July 1, 2011  
Subject: **Portland Marine Terminal**  
Federal Project No: DTMA1G10006/TIGER  
State PIN: 017820.00  
**Amendment No. 2**

Make the following change to the Bid Document:

A.A1

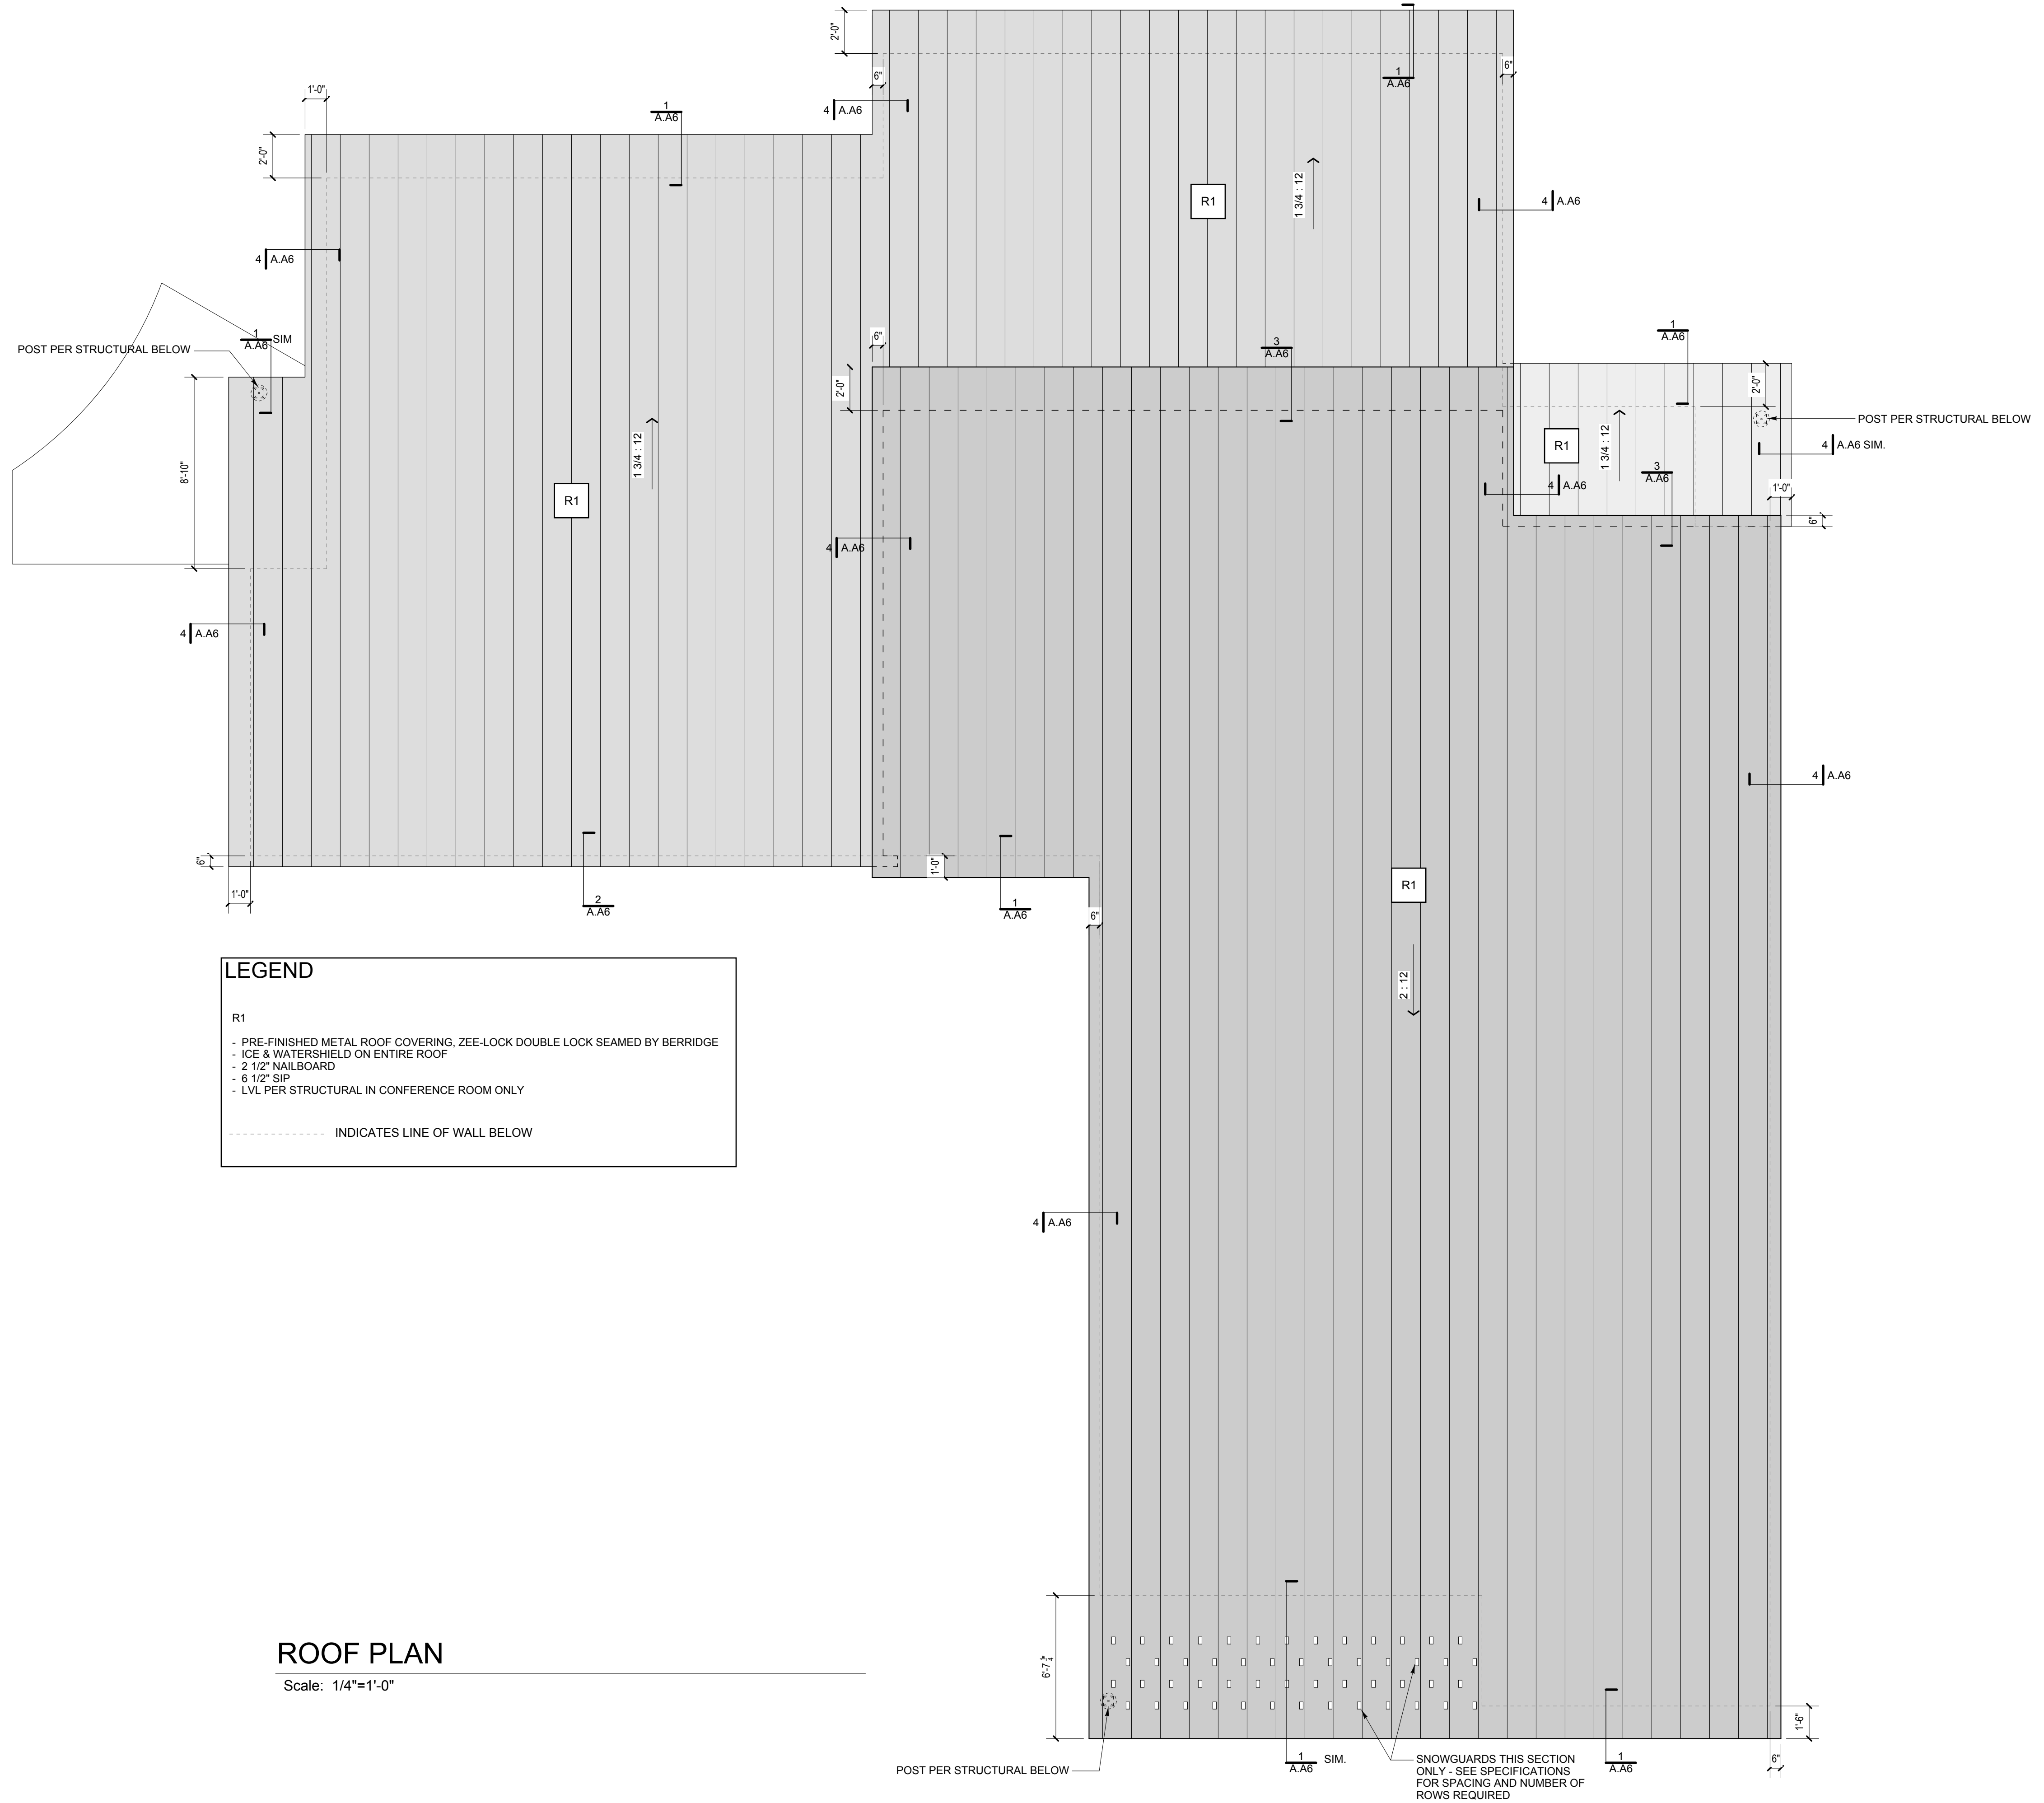
**Question:** On sheet A.A1, the Security Office has a type W1 and type W2 window. These windows are not shown on the window schedule or the door & frame schedule. Please clarify.

**Response:** Interior windows “W1” and “W2” are shown on the Ground Floor Plan on Sheet A.A1 and on interior elevations A/A.A12, 4/A.A13, and 1/A.A13 but they do not appear on the door and frame schedule on Sheet A.A9.

W1 is a fixed glass unit with hollow metal frame as shown in the attached sketch.  
W2 is a hollow metal frame with sliding glass panels as shown in the attached sketch.

C BUILDING SECTION CONFERENCE ROOM
SCALE: 1/4" = 1'-0"

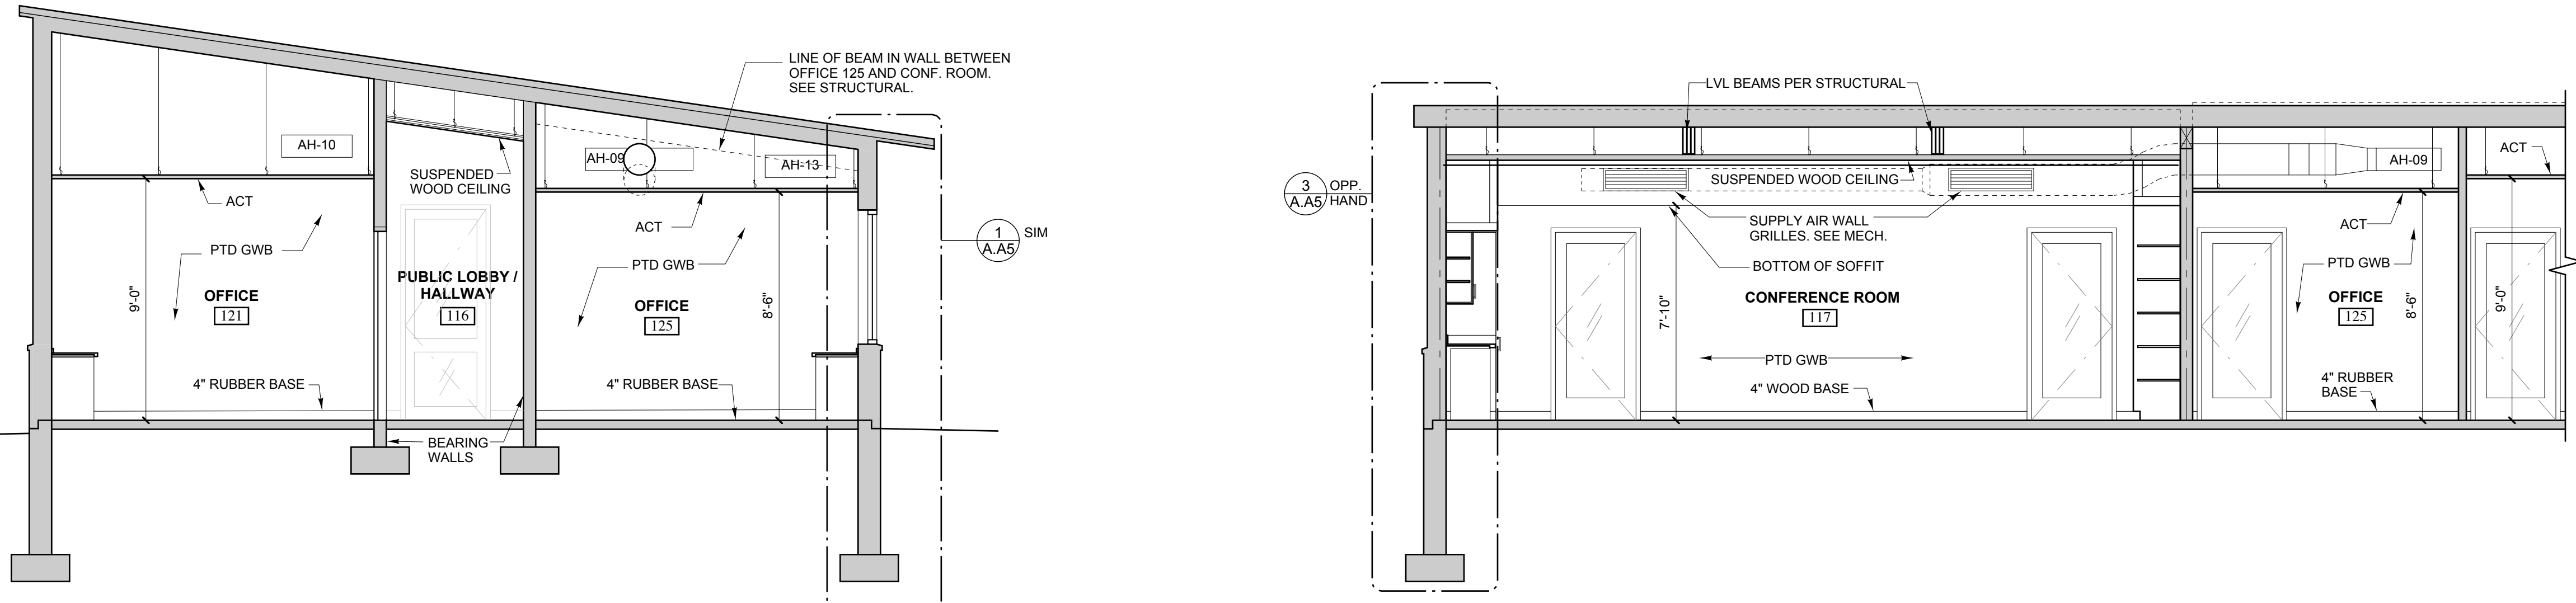
**Question:** Ceiling Type C2 on A.A14 does not indicate any GWB in that system. If you look at the section through Conference Room 117 1&2 on A.A5 there seems to be GWB above the wood ceiling. Please clarify.

**Response:** There is no GWB required as part of the C2 ceiling assembly.
